Planning Application Ref: R/20/21/T

Location: St Peters & St Pauls Church, 77 The Street, Rustington, BN16 5NL

Description of works: To crown lift 1no. yew tree (*Taxus baccata*) to 2.5m above ground level. To crown lift 1no.lime (*Tilia*) tree to 3m above ground level. To remove all dead wood from 1no. strawberry tree (*Arbutus unedo*)

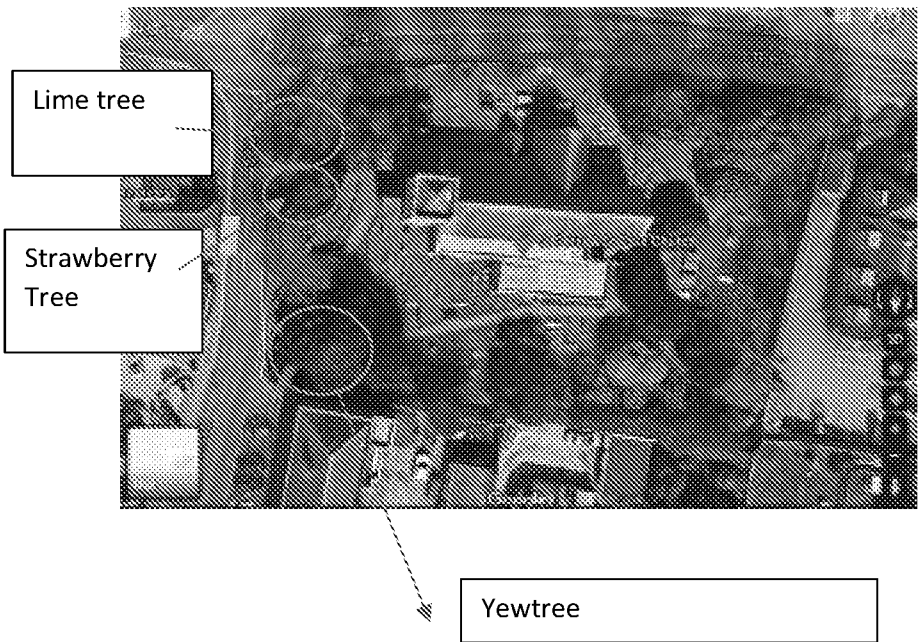
| <ul style="list-style-type: none">- Outwardly appears to be in a fine physiological state. Large low limbs/branches have been allowed to develop; whilst adding character to the tree those have begun to obstruct access to graves/headstones and encroach low over paths. A prominent tree of high amenity value. | | | |
| <ul style="list-style-type: none">- No strawberry tree found at the marked location, although this is similar in appearance and the most likely candidate for the work proposal. It is multi-stemmed with asymmetric form. No obvious deadwood although a twin-stemmed, early mature beech (dormant) grows from within the bay stem cluster, so care needed to ensure it is left untouched.- The removal of dead branches is an exception and does not require consent from the local planning authority. | | | |
| <ul style="list-style-type: none">- Outwardly appears to be in a fair physiological state and with good form. A prominent tree of high amenity value. | | | |

- The work proposed is justified on arboricultural grounds. If undertaken to a good standard and at the right time; then it is unlikely to have an adverse effect on the trees long-term vitality and visual amenity.
- T1 - This tree requires careful management that respects its age and vulnerability to environmental changes and disease progression. The pruning should be carried out by a skilled practitioner to ensure heavy branches are removed in a controlled manner and final cuts (pruning wounds) are correctly positioned.

- I recommend **CONSENT** for this application, subject to the following condition:

- Part a) Where whole branches are to be removed and final cuts made close to the trunk or branch union they are to be made as shown in Figure 2 of BS3998:2010
- Part b) Where branches are to be shortened back the final cuts are to be made at the correct angle shown in BS3998:2010 and adjacent to a live bud or lateral.

- The long-term vitality of tree (**T1 yew**) is best respected when significant pruning work such as proposed, is undertaken during either the late summer or late winter periods (late January/February or late July/August). The work proposed should only be undertaken during those periods.
